CITY OF ALBUQUERQUE

Re: Gyro Shack Commissary
3210 Candelaria Rd. NE
Traffic Circulation Layout
Architect's Stamp 07-01-22 (H16-D111)

Based upon the information provided in your submittal received 07-07-22, the above referenced plan cannot be approved for Building Permit until the following comments are addressed:

### 4 PARKING SPACE STRIPING

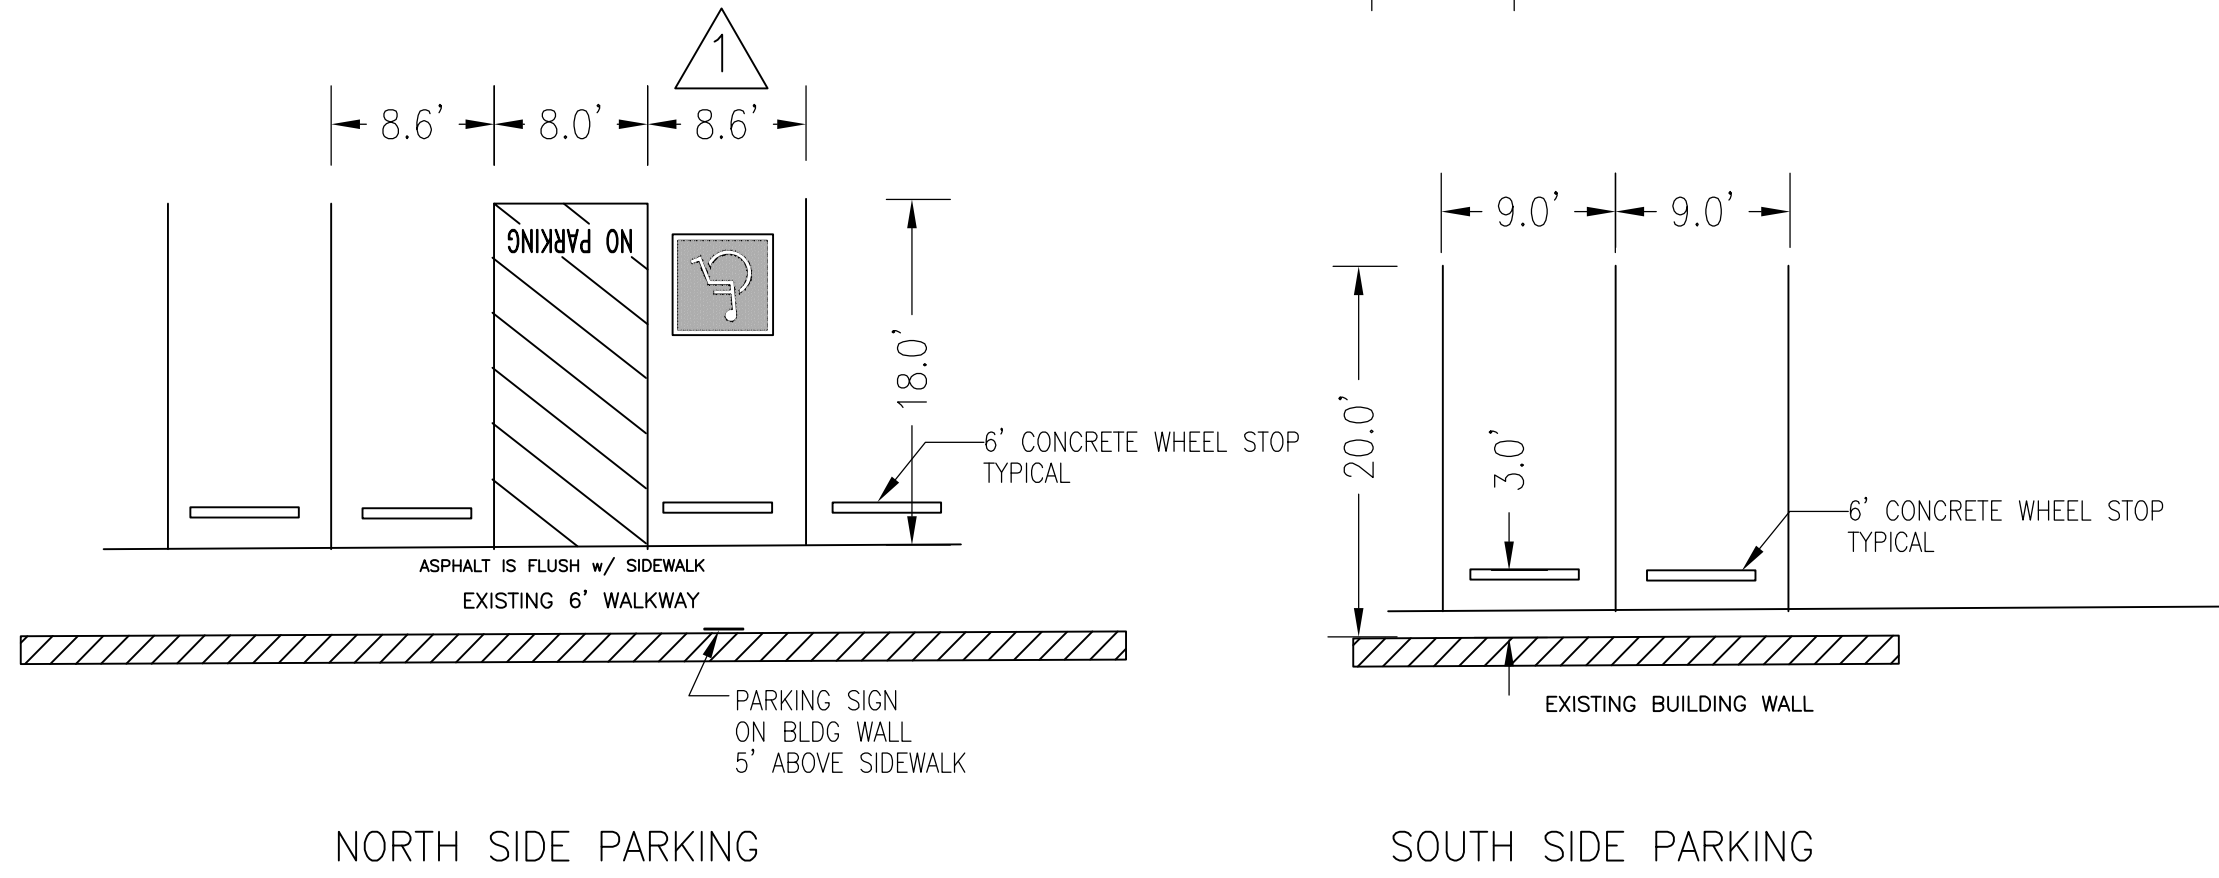
3. ADA Van parking stall width should be min. 8.5 ft.
4. ADA curb ramps must be updated to current standards and have truncated domes installed.
5. All bicycle racks shall be designed according to the following guidelines:

### 5 ALBUQUERQUE BIKE RACK

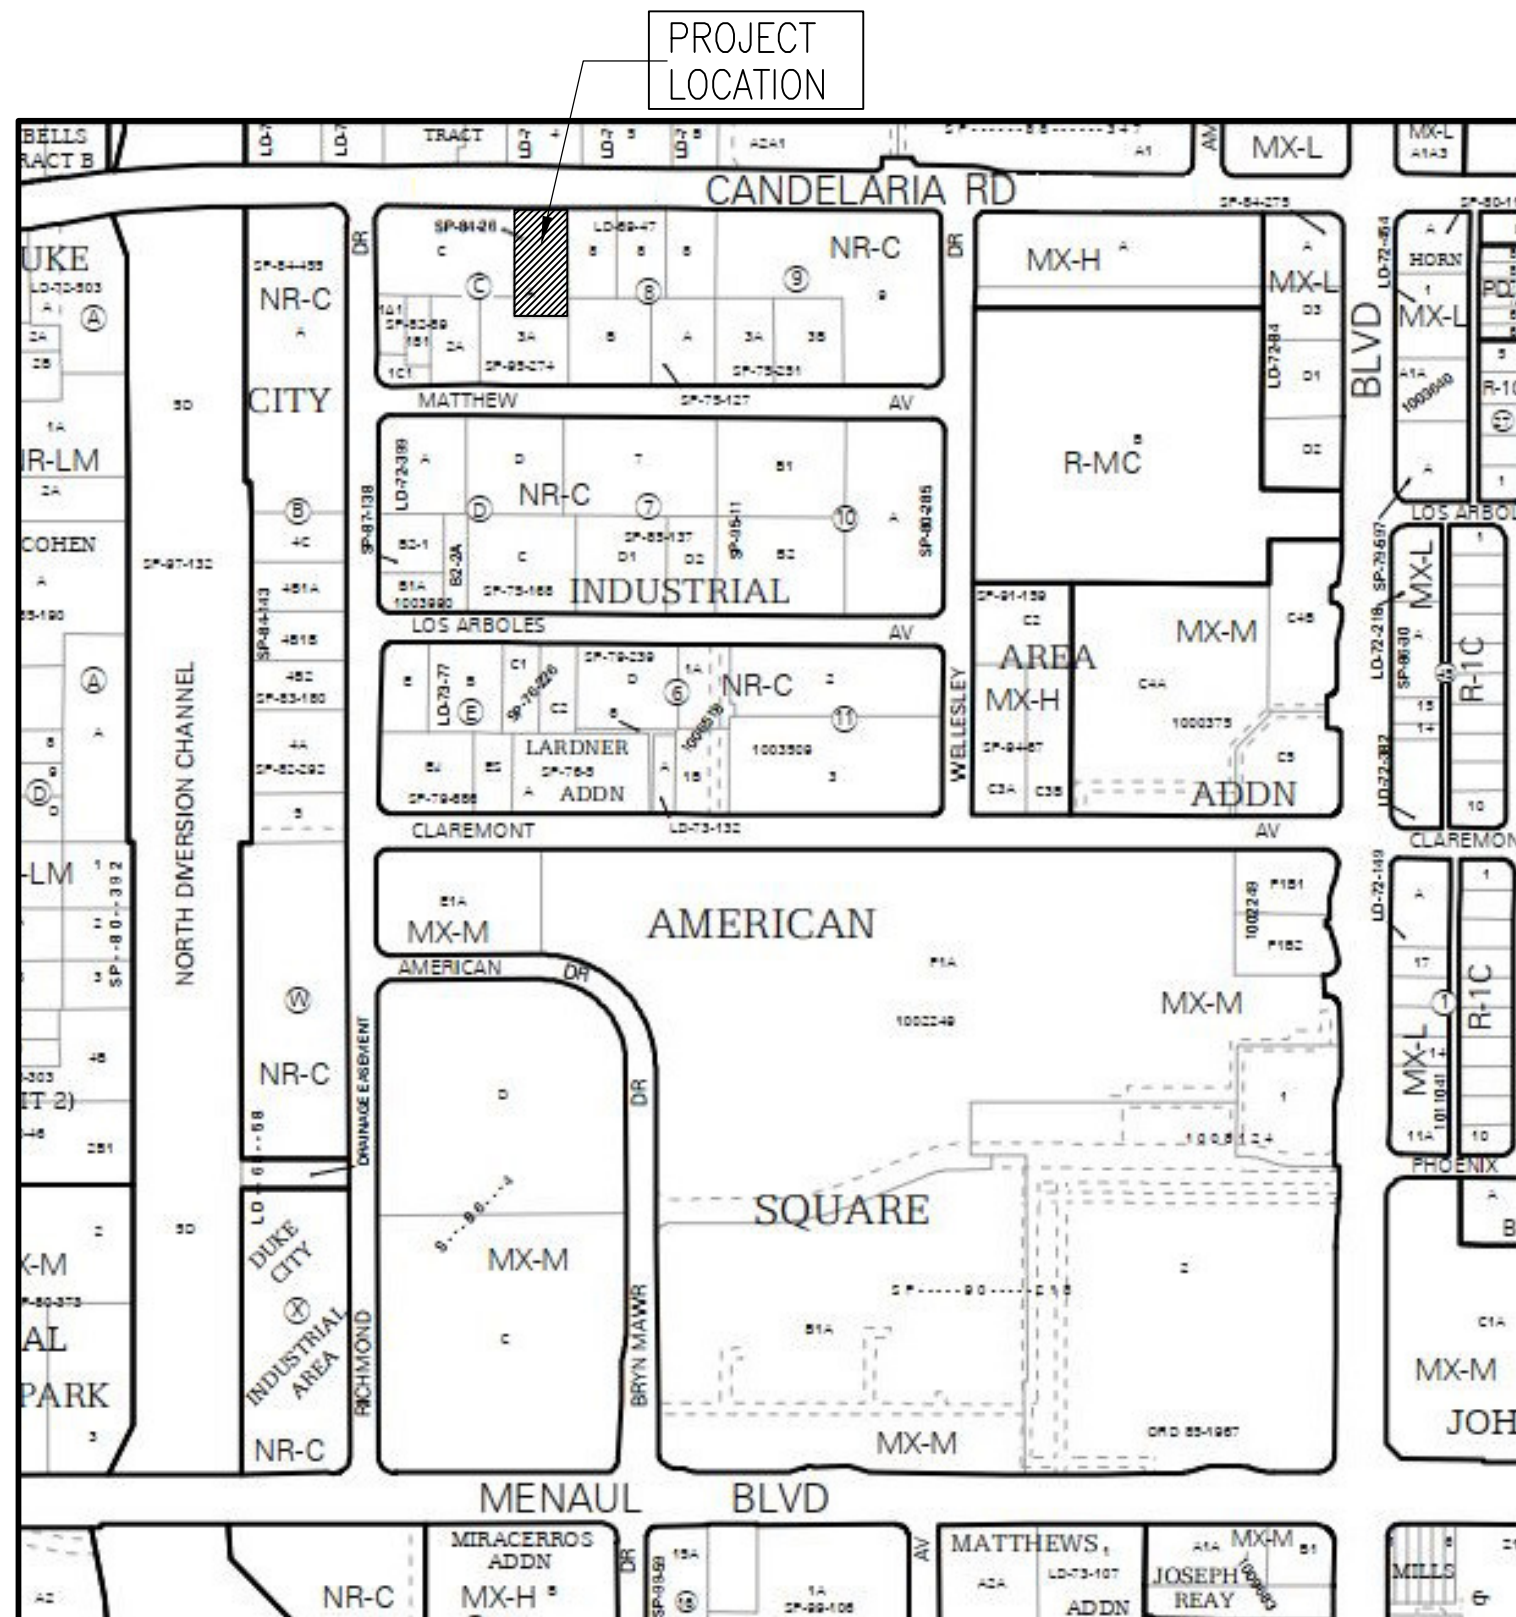
- a. The rack shall be a minimum 30 inches tall and 18 inches wide.
 - b. The bicycle frame shall be supported horizontally at two or more places. Comb/toaster racks are not allowed.

- c. The rack shall be designed to support the bicycle in an upright position. See the IDO for additional information.
 - d. The rack allows varying bicycle frame sizes and styles to be attached.

- e. The user is not required to lift the bicycle onto the bicycle rack.
 - f. Each bicycle parking space is accessible without moving another bicycle.

6. Bicycle racks shall be sturdy and anchored to a concrete pad.
7. A 1-foot clear zone around the bicycle parking stall shall be provided.
8. Bicycle parking spaces shall be at least 6 feet long and 2 feet wide.

### 1 SITE LAYOUT PLAN

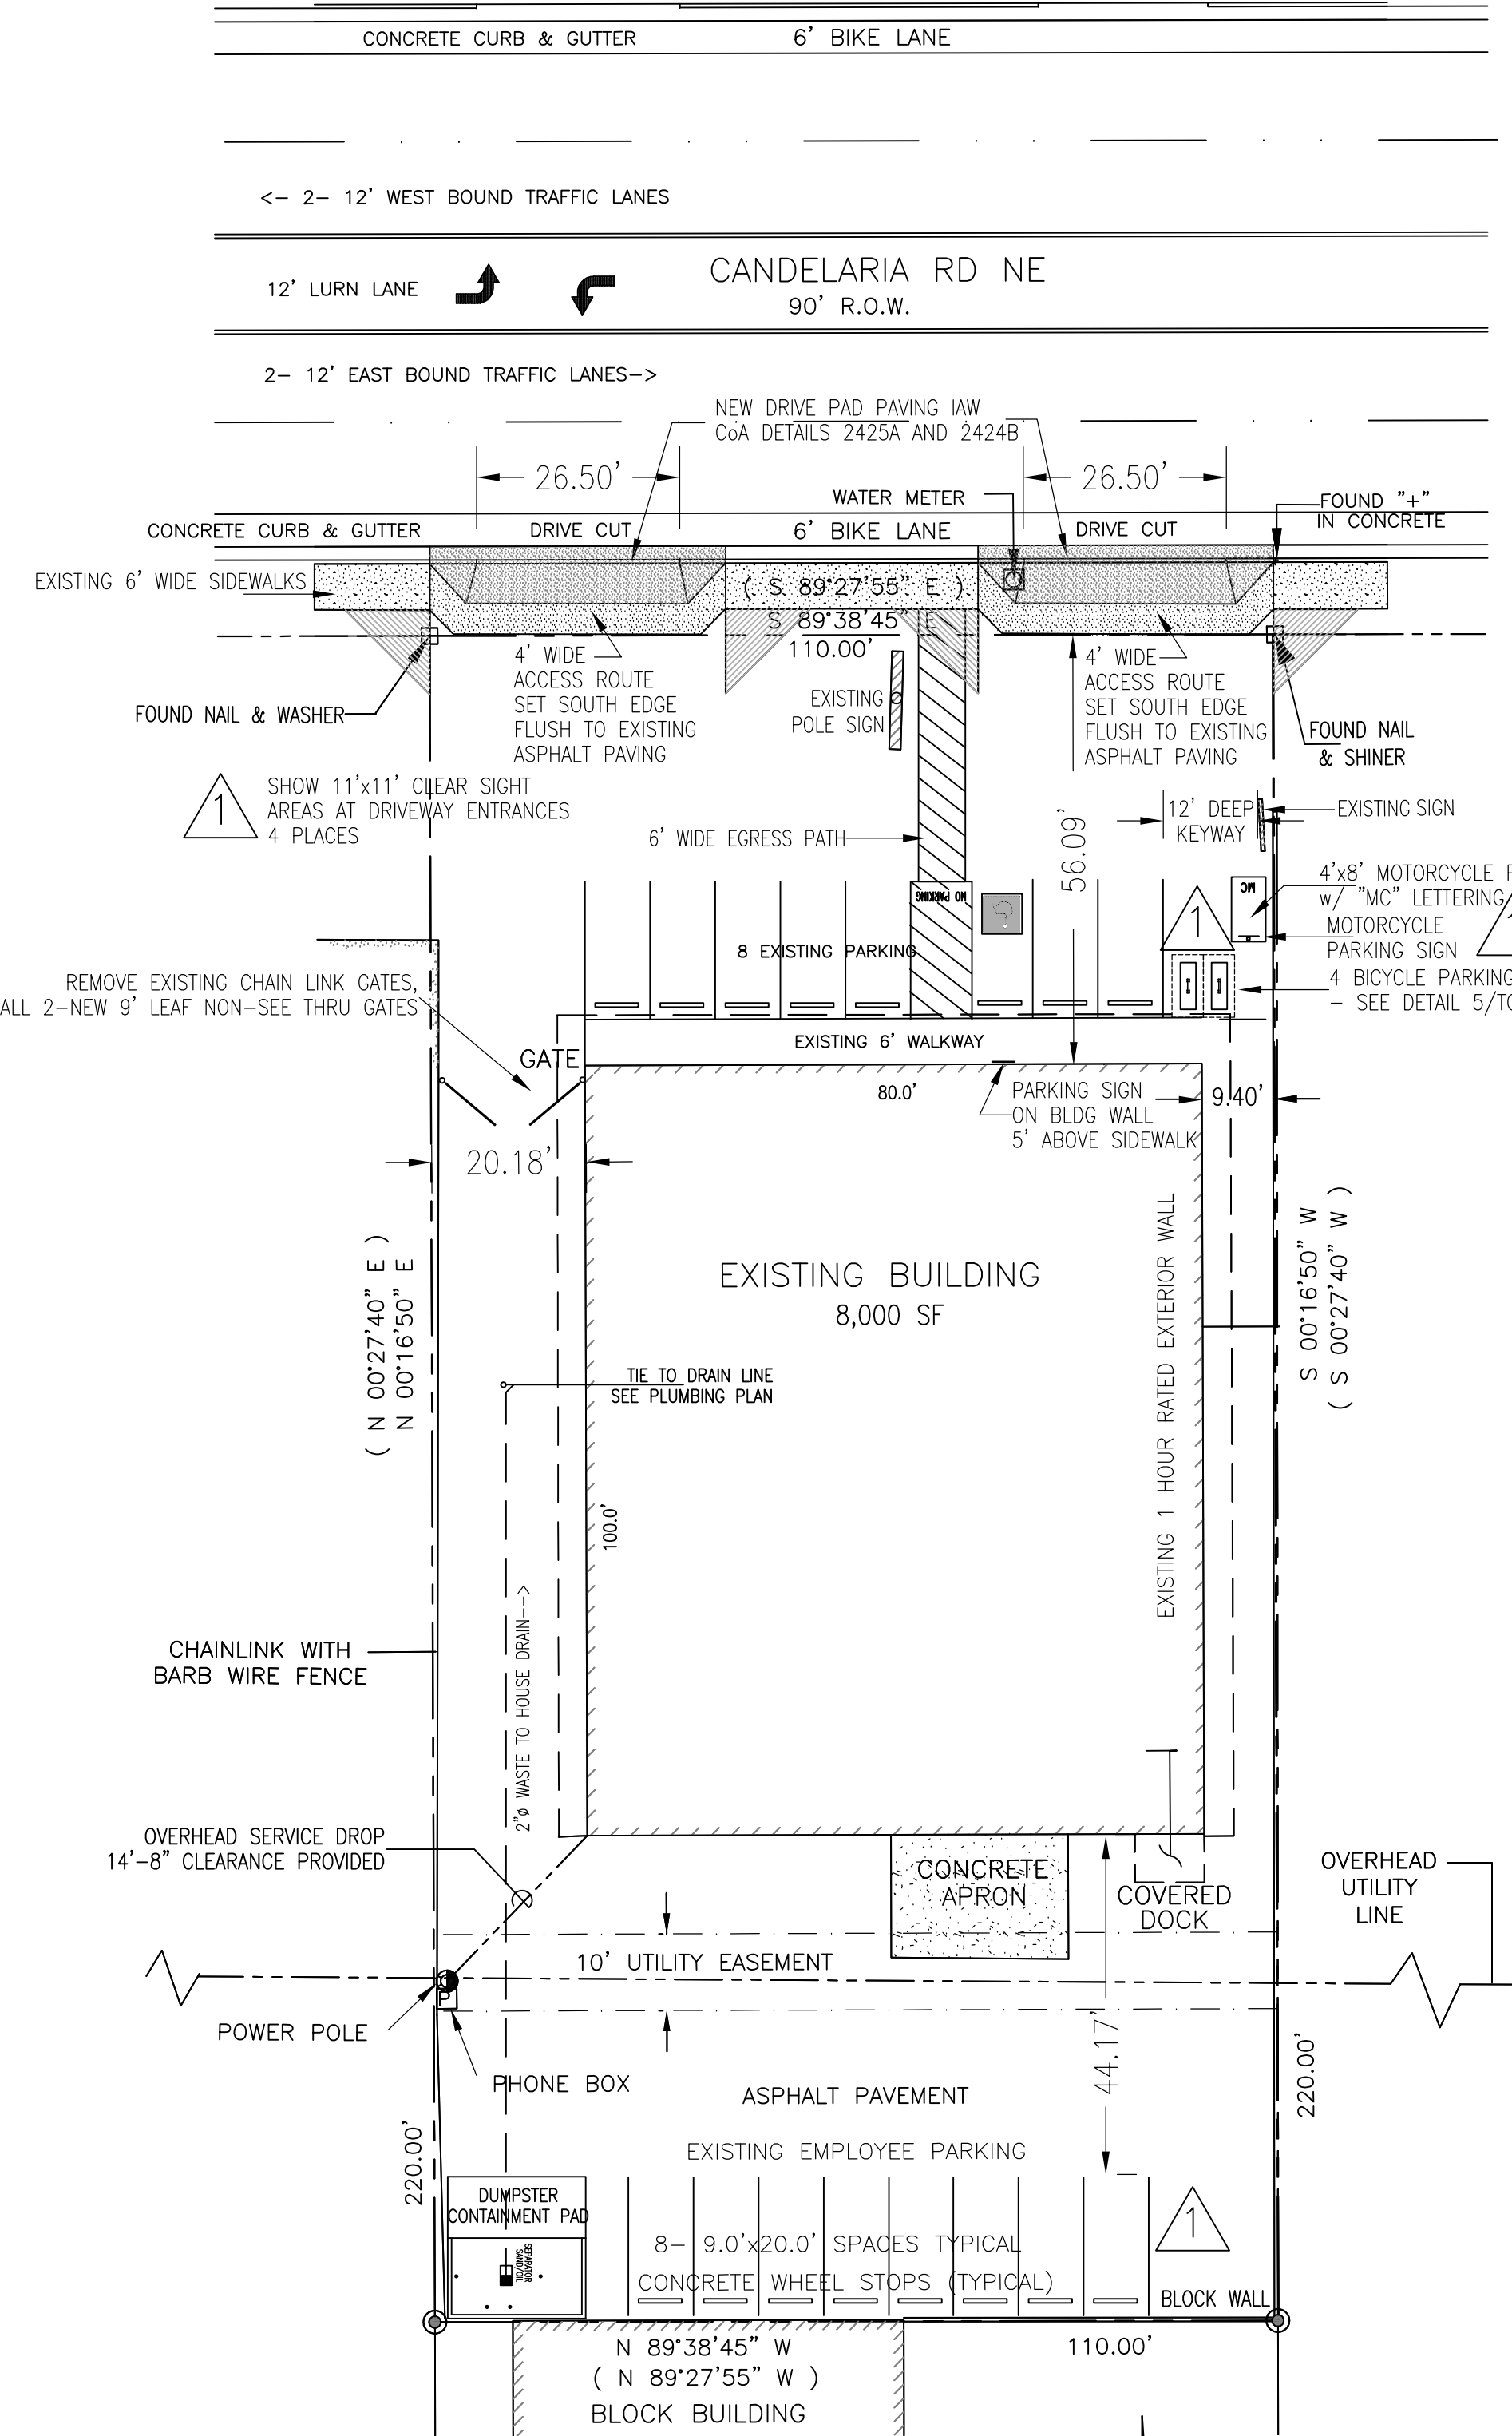
1. Identify the right of way width, medians, curb cuts, and street widths on Candelaria Rd. NE.
2. Curn Return design is recommended as a driveway access off Candelaria Rd. please address this concern.

9. A 5 ft. keyway is required for dead-end parking aisles.
10. Refuse vehicle maneuvering shall be contained on-site. The refuse vehicle shall not back into the public right of way.; provide a copy of refuse approval.

11. Please provide a sight distance exhibit

12. Show the clear Intersection sight triangle and add the following note to the plan:
"Landscaping and signage will not interfere with clear sight requirements. Therefore, signs, walls, trees, and shrubbery between 3 and 8 feet tall (as measured from the gutter pan) will not be acceptable in the clear sight triangle. Please see attached Intersection sight triangle.

13. Please specify the City Standard Drawing Number when applicable.
14. Add a note stating "All broken or cracked sidewalk must be replaced with sidewalk and curb & gutter." A build note must be provided referring to the appropriate City Standard drawing.
